From: Lauren Willard [REDACTED]
Sent: 04 August 2015 12:46
To: David Easton
Subject: RE: EP/91/15/HH - 7 Seaview Road

From: David Easton [<mailto:David.Easton@arun.gov.uk>]
Sent: 28 July 2015 15:25
To: [REDACTED]
Subject: EP/91/15/HH - 7 Seaview Road

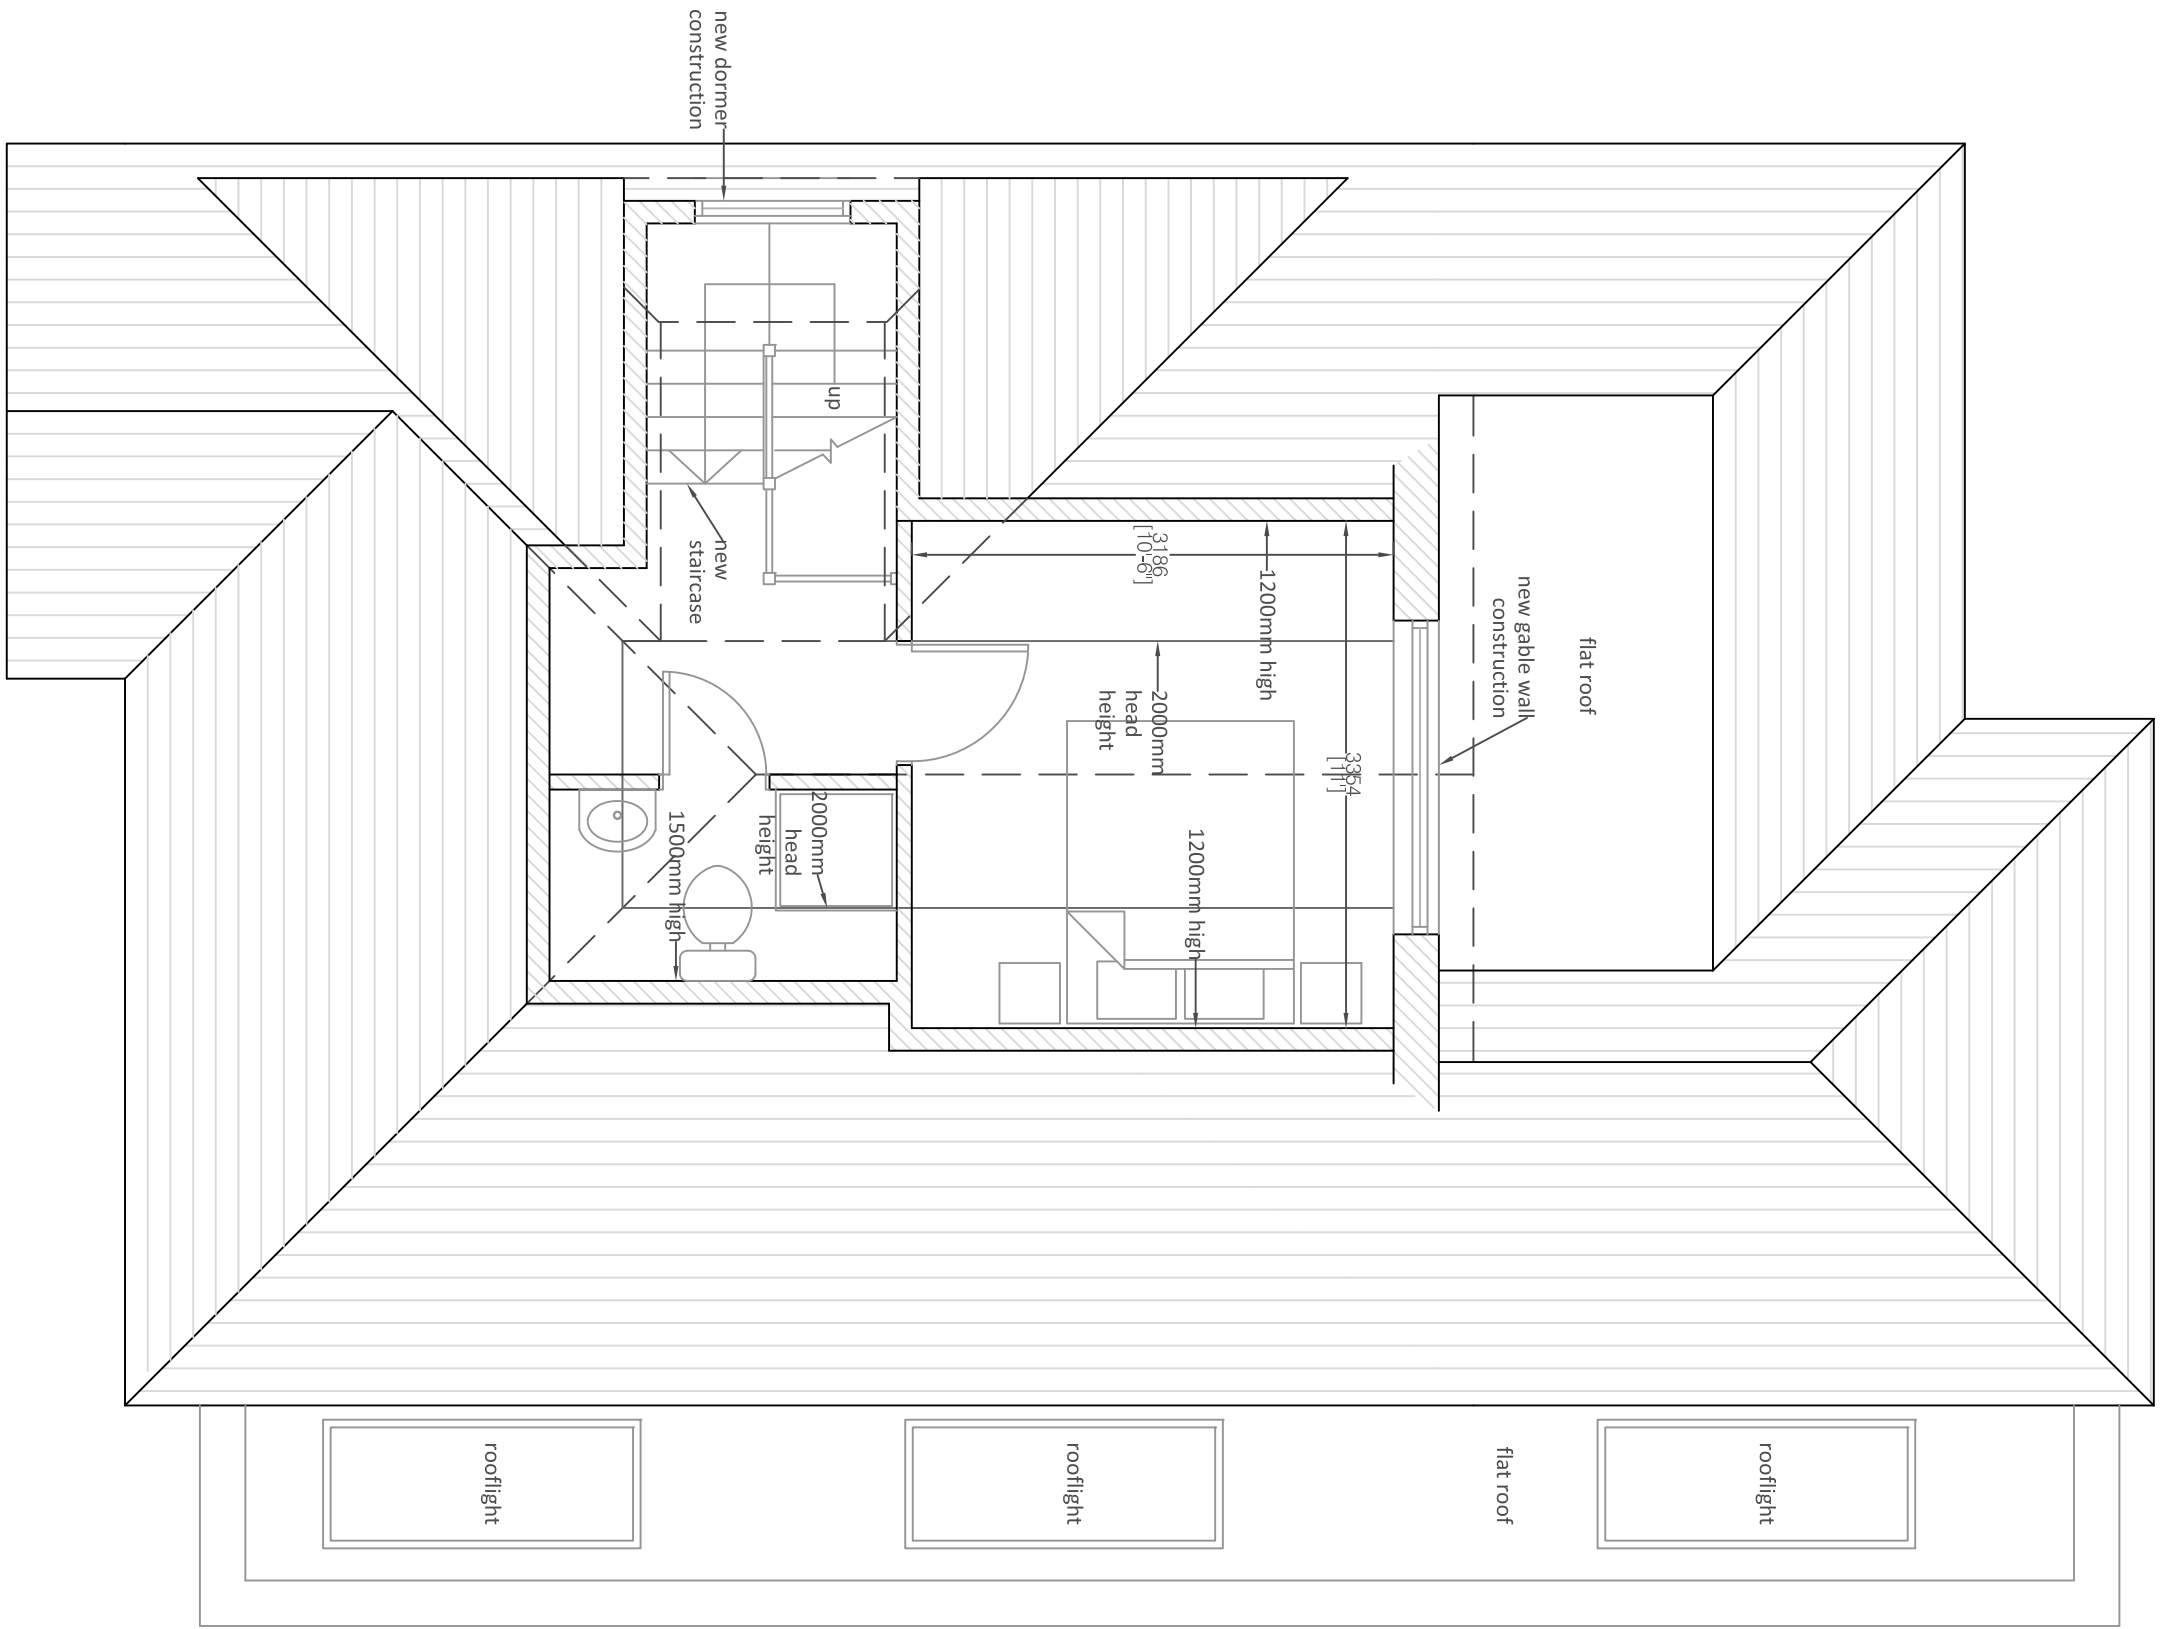
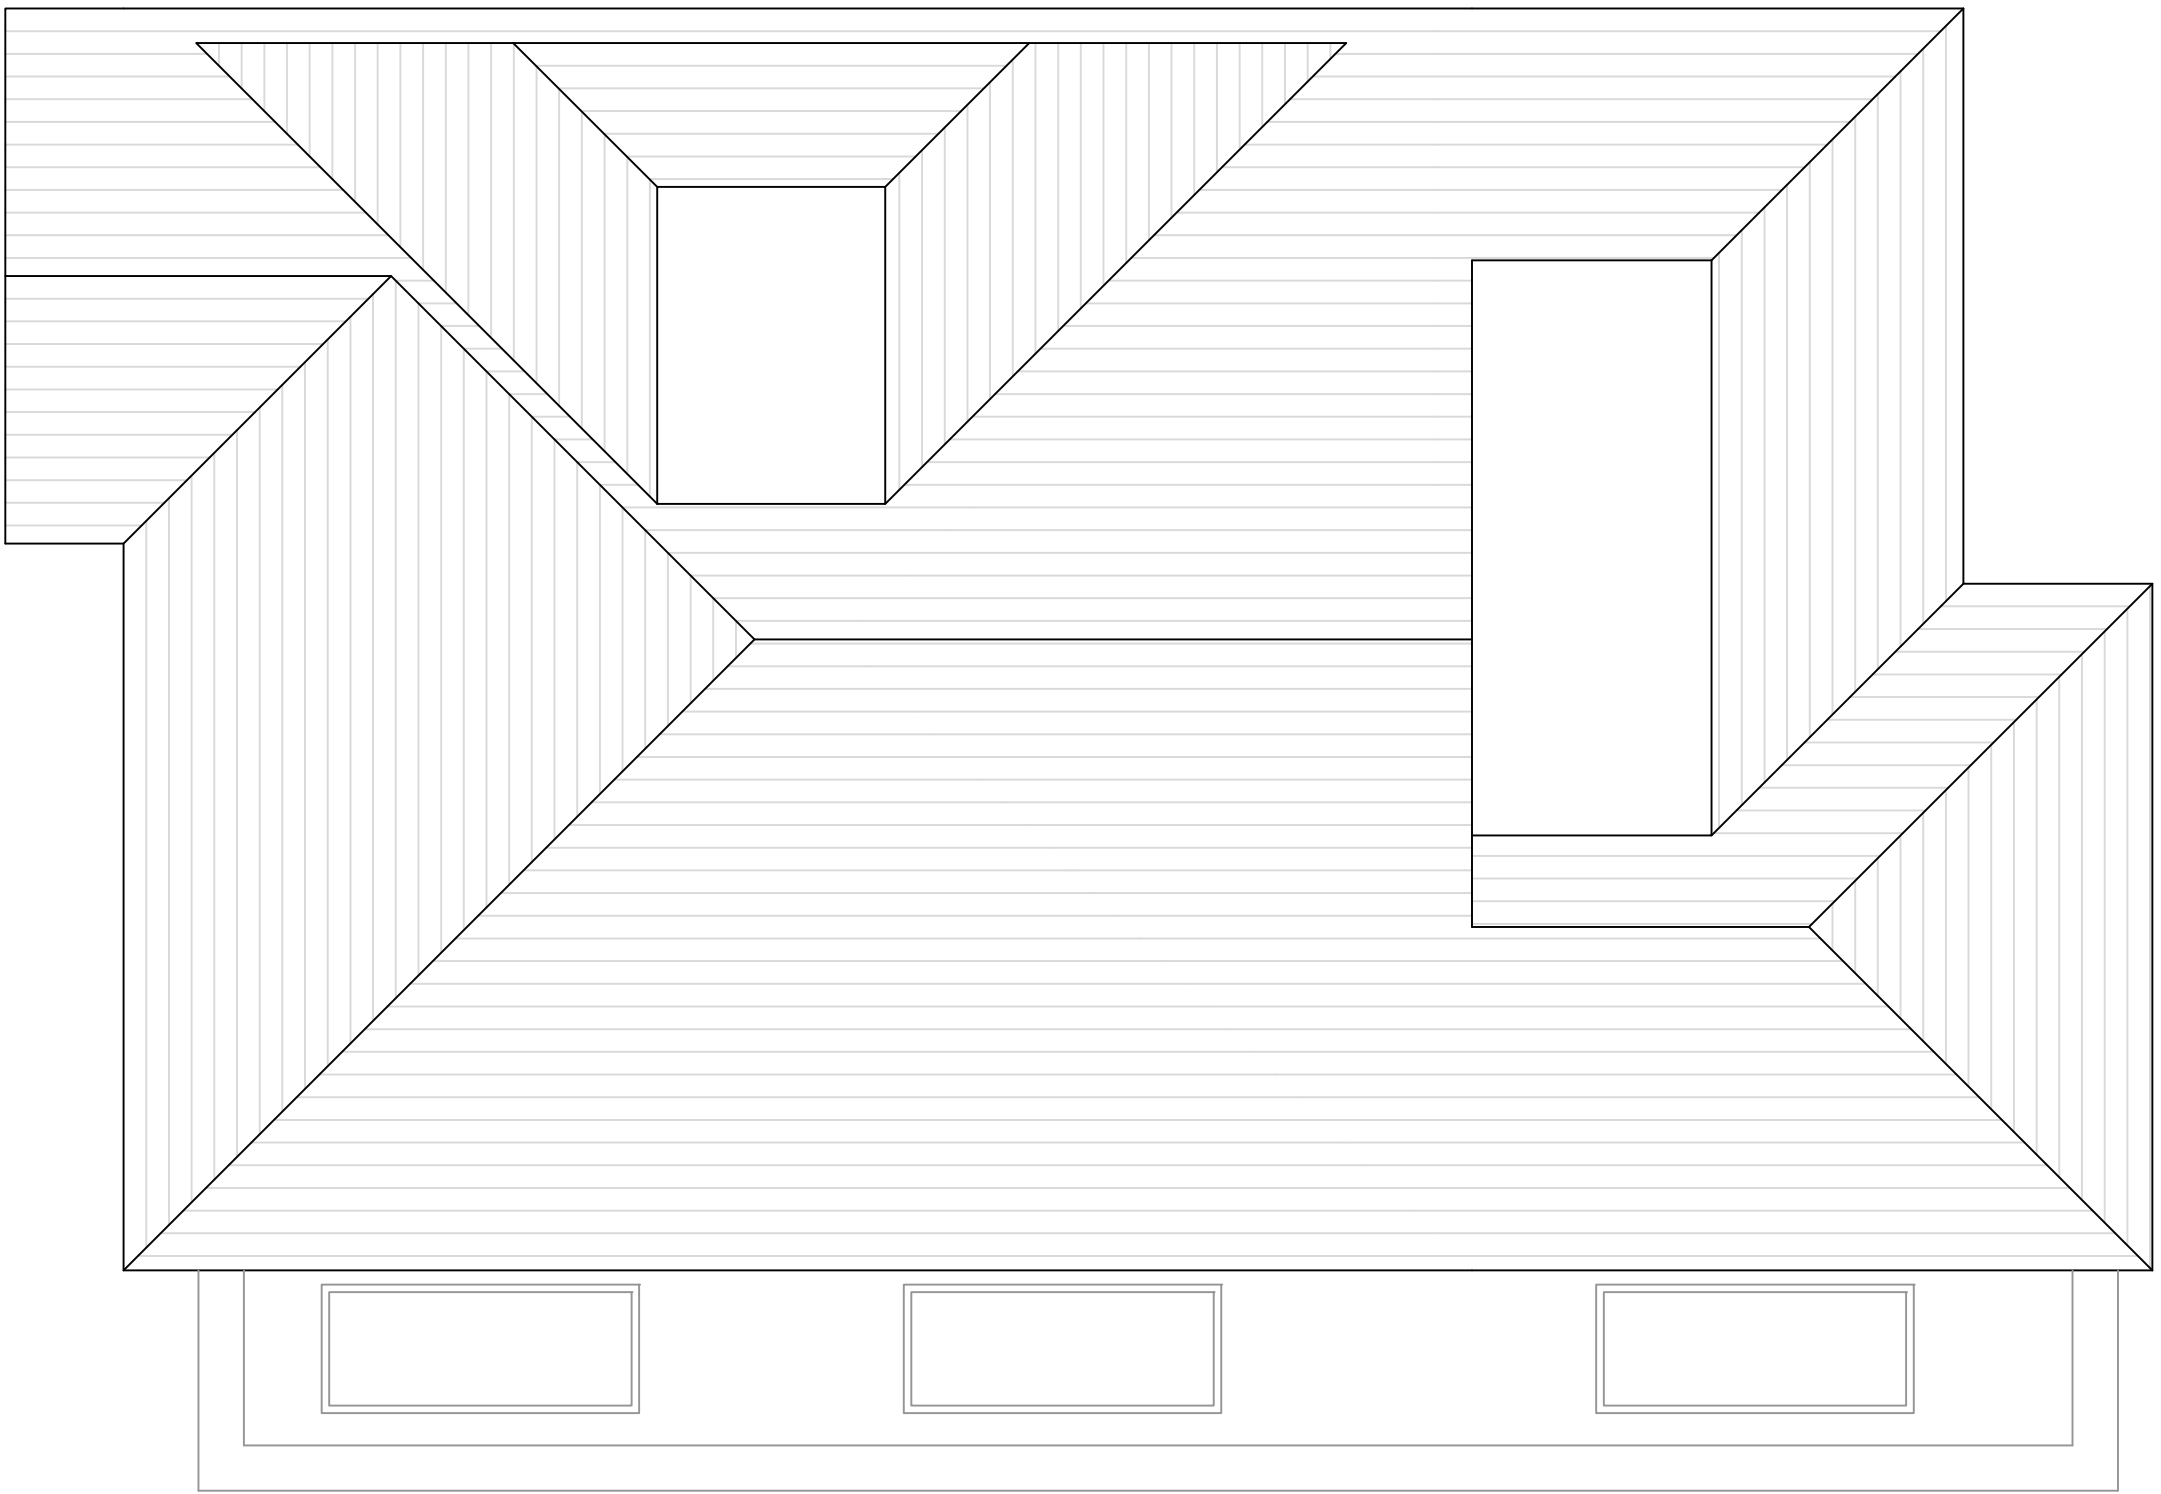
I remain concerned in relation to the proposed roof design (regardless of the presence of the dormer window) due to its proposed layout and shape and the impact this will have upon the character of the dwelling. I can also confirm that having spoken with my team leaders in relation to this application they are also of the opinion that the proposal due to the design of the roof will not appear subservient or integrated with the host dwelling.

Have you take into account the roofs to be created above the proposed two storey rear extension as this must also be taken into account of the roof space created. I have calculated the rear roofs as totalling 29.7m³ which when added to my gable calculation of 23.48m³ gave the total of 53.21m³.

Please find attached revised drawings which have had the alterations to the existing roof omitted.
